**Application Reference:** 6/2018/3084/COND

**Proposed development at:** 17 Kingsmead Cuffley Potters Bar EN6 4AN

**Proposal:** Submission of details pursuant to condition 3 (area for parking, storage and delivery of materials associated with construction), 4 (tree protection plan and arboricultural method statement), 5 (hard and soft landscaping) and 7 (samples of materials for construction of external surfaces) on planning permission 6/2016/0291/FULL

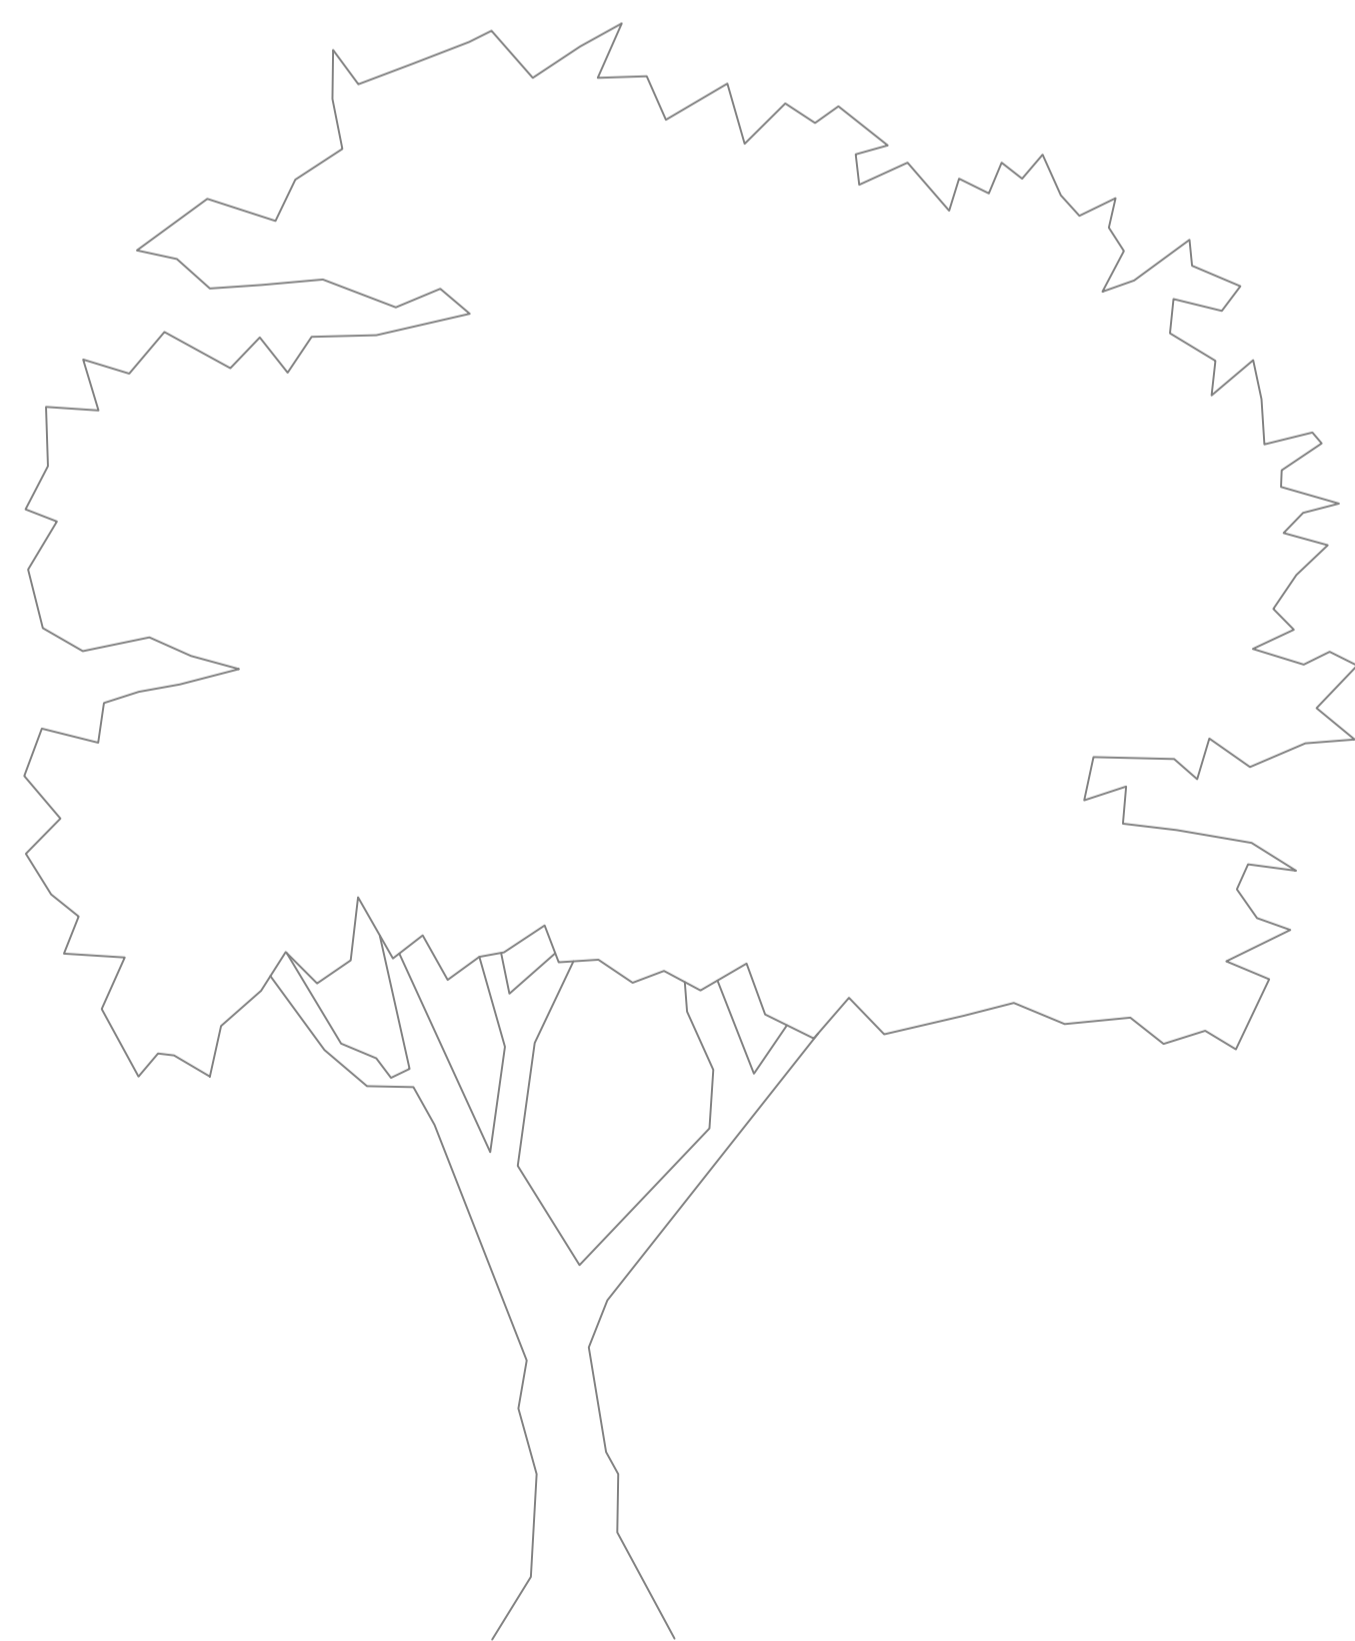
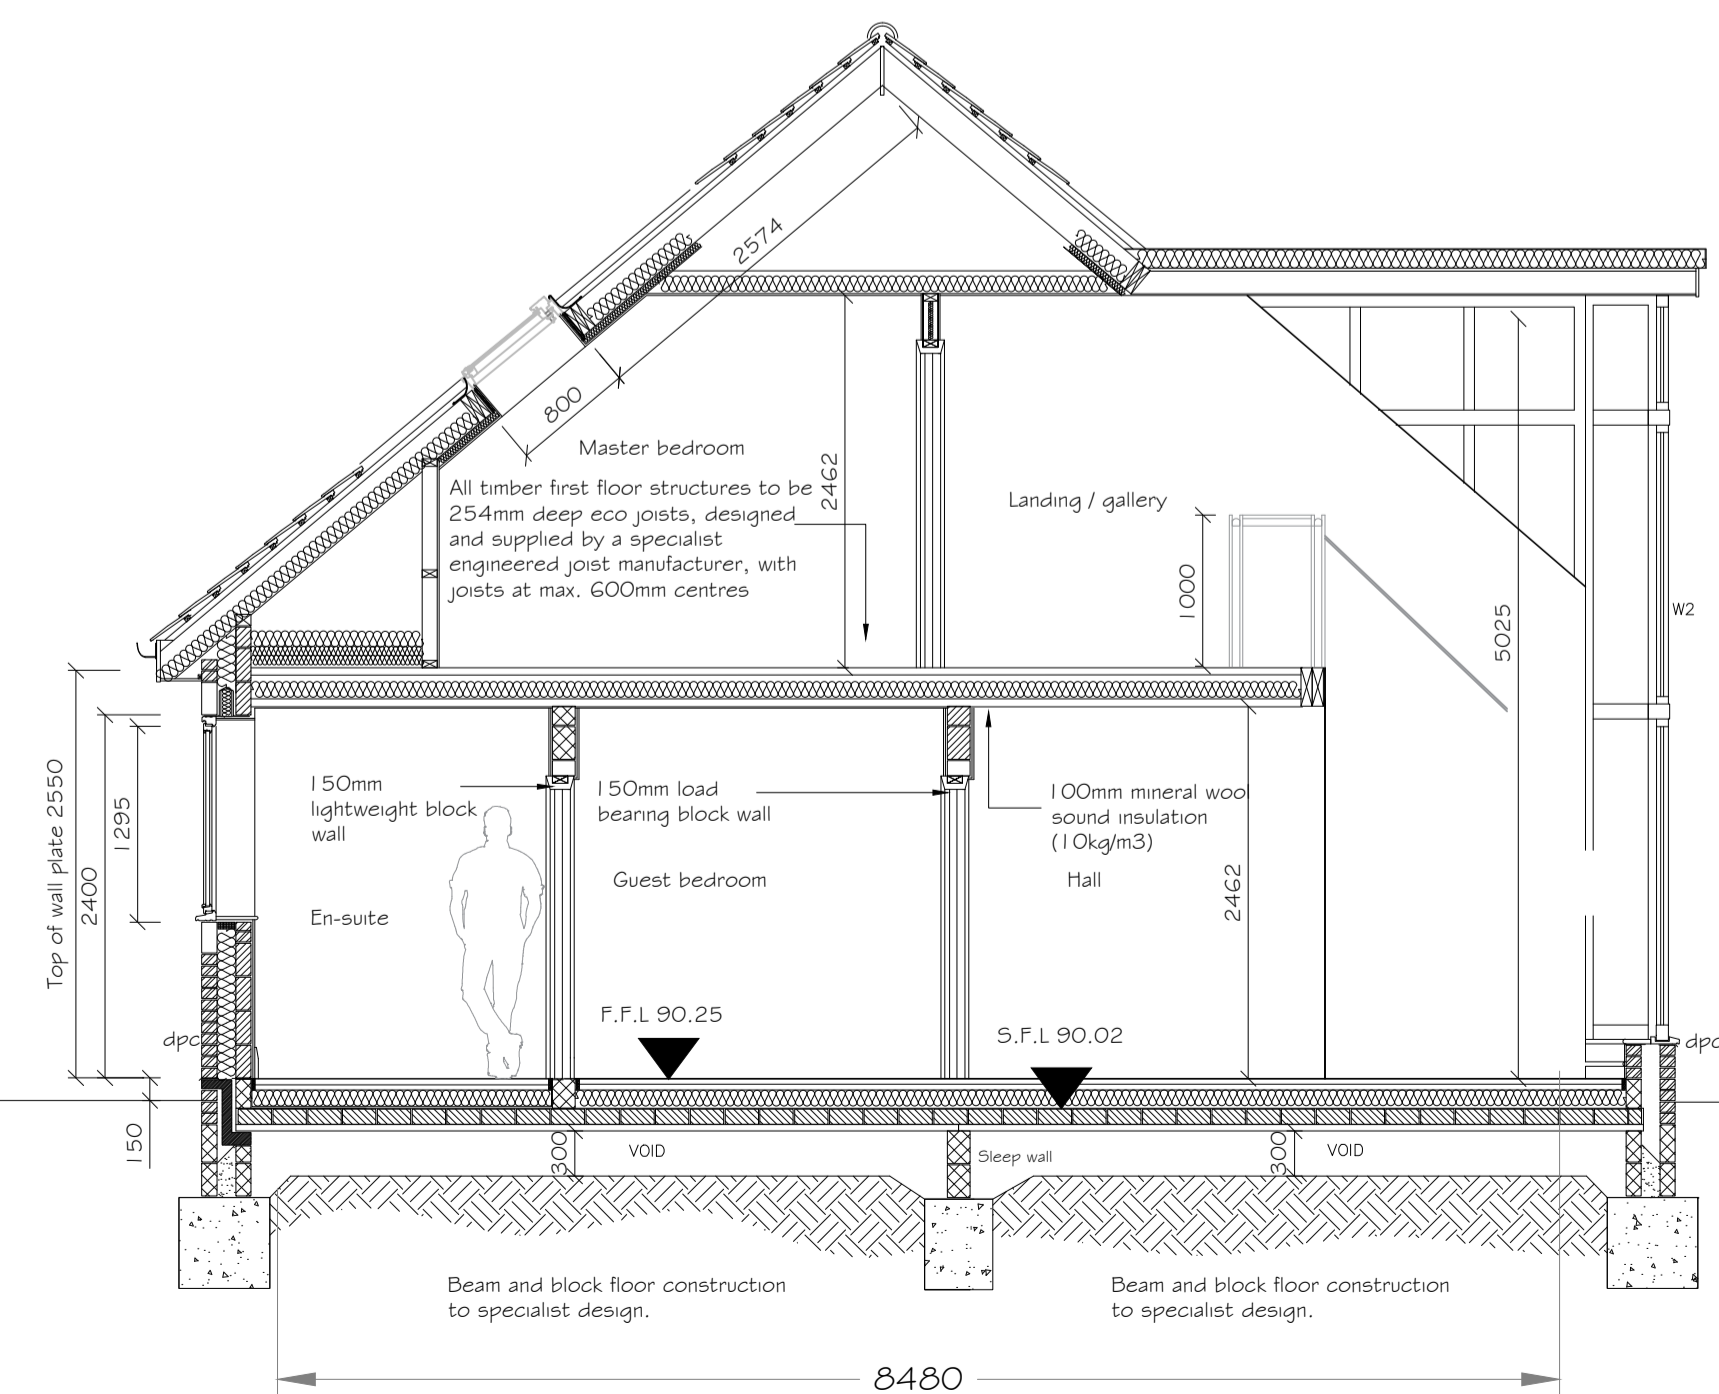
- PL 02 received 04/12/2018
- 3014-18A1-01 and 3014-18A1-02, received 17/12/2018
- 3014-18A2-04 Rev A, received 28/01/2019

The information submitted does not address all of the requirements of condition 5. Whilst details of proposed levels have been provided, there are no details of existing levels for comparison (point b); details of retained trees have not been identified (point e); and a landscape maintenance plan has not been submitted (point f).

Whilst insufficient information has been provided to discharge condition 5 in full, based on the details provided, I can confirm that the information submitted in respect of points a, c and d are acceptable.

Prior to the commencement of any above ground development, further information is required in respect of condition 5 (b), (e) & (f).

Drawing No: 3014-18A2-03	Revision:
-----------------------------	-----------

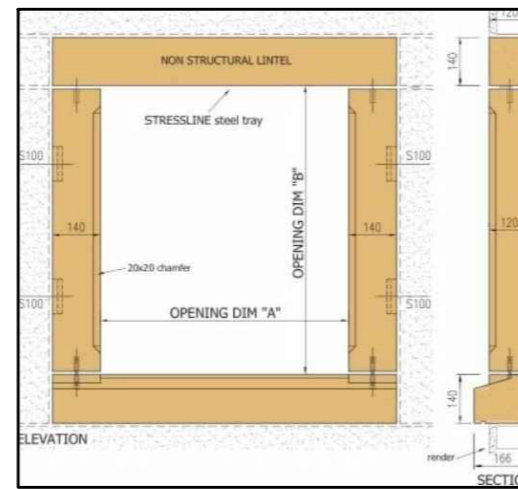
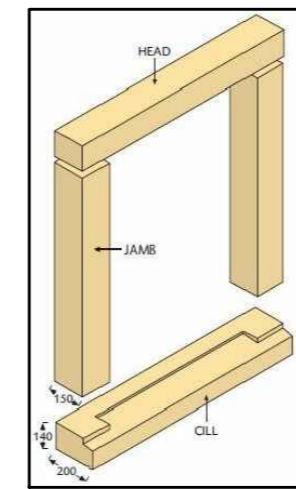
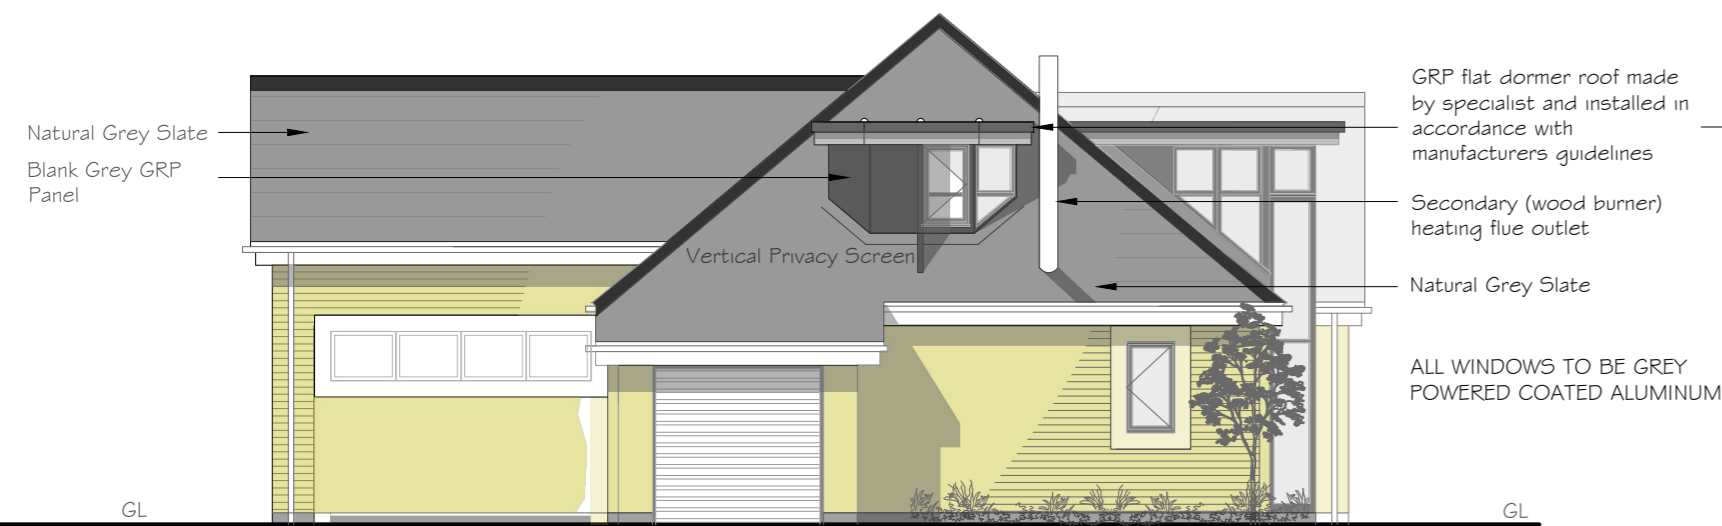
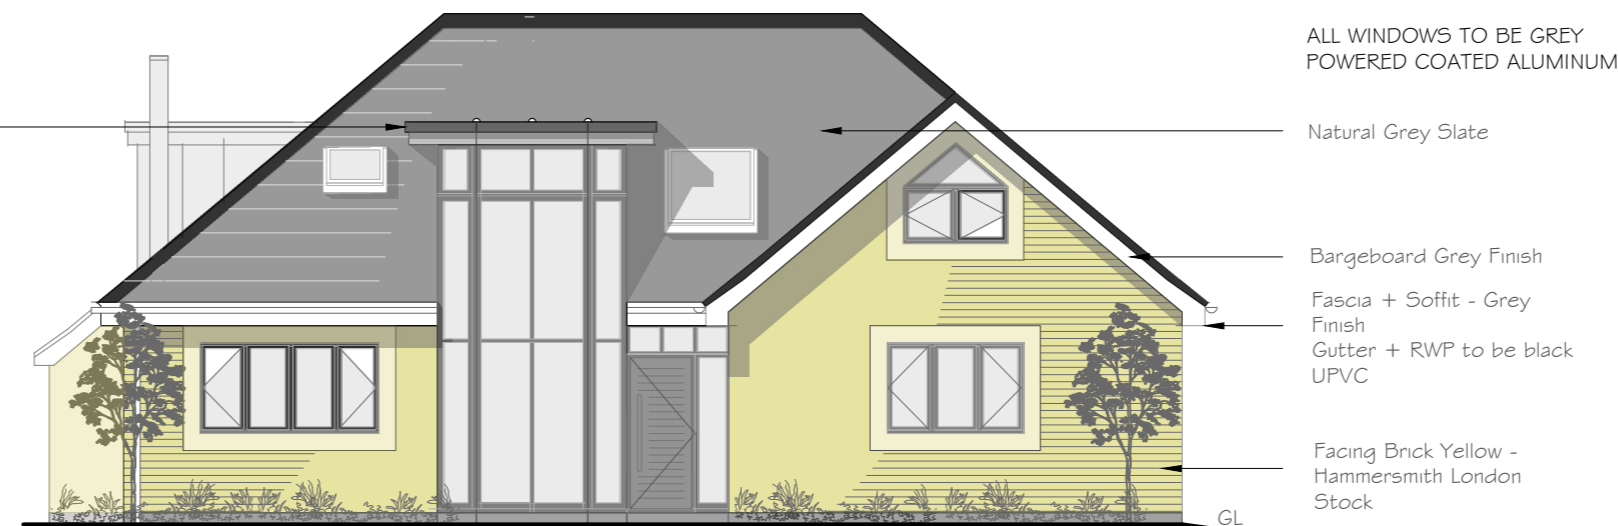
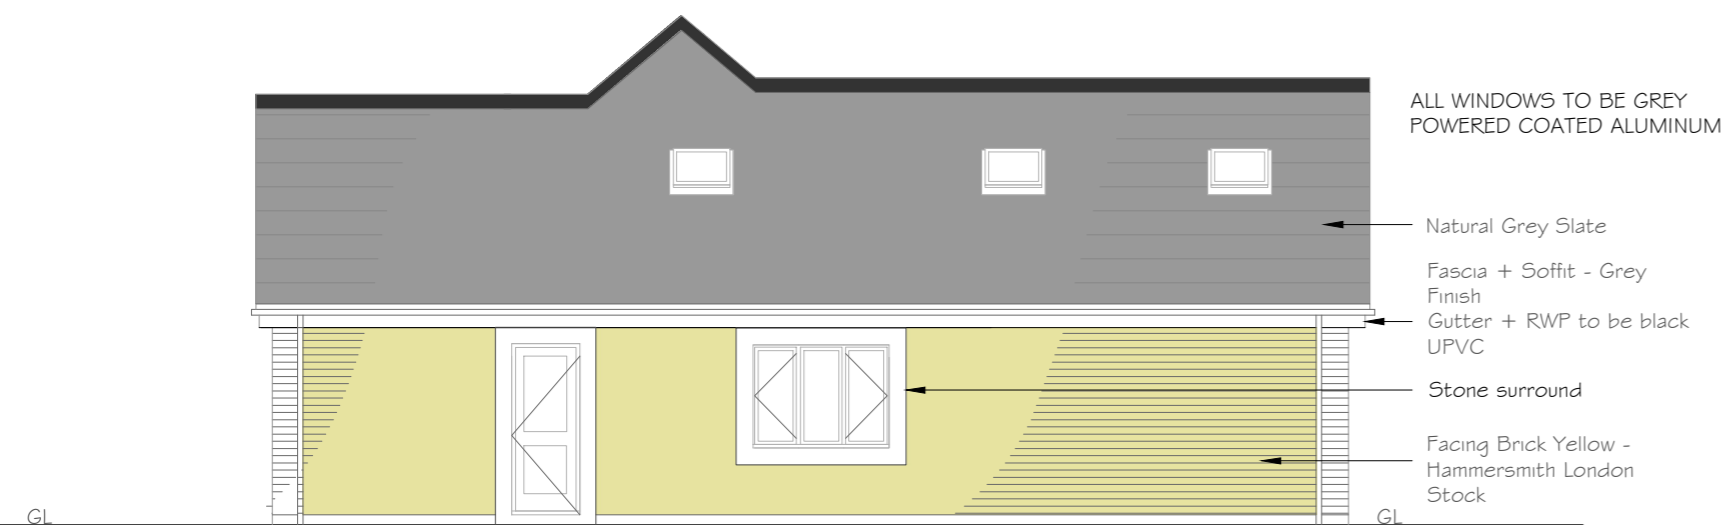
The proposed materials for construction of external surfaces are acceptable in accordance with drawing 3014-18A2-03, dated 17/12/2018.
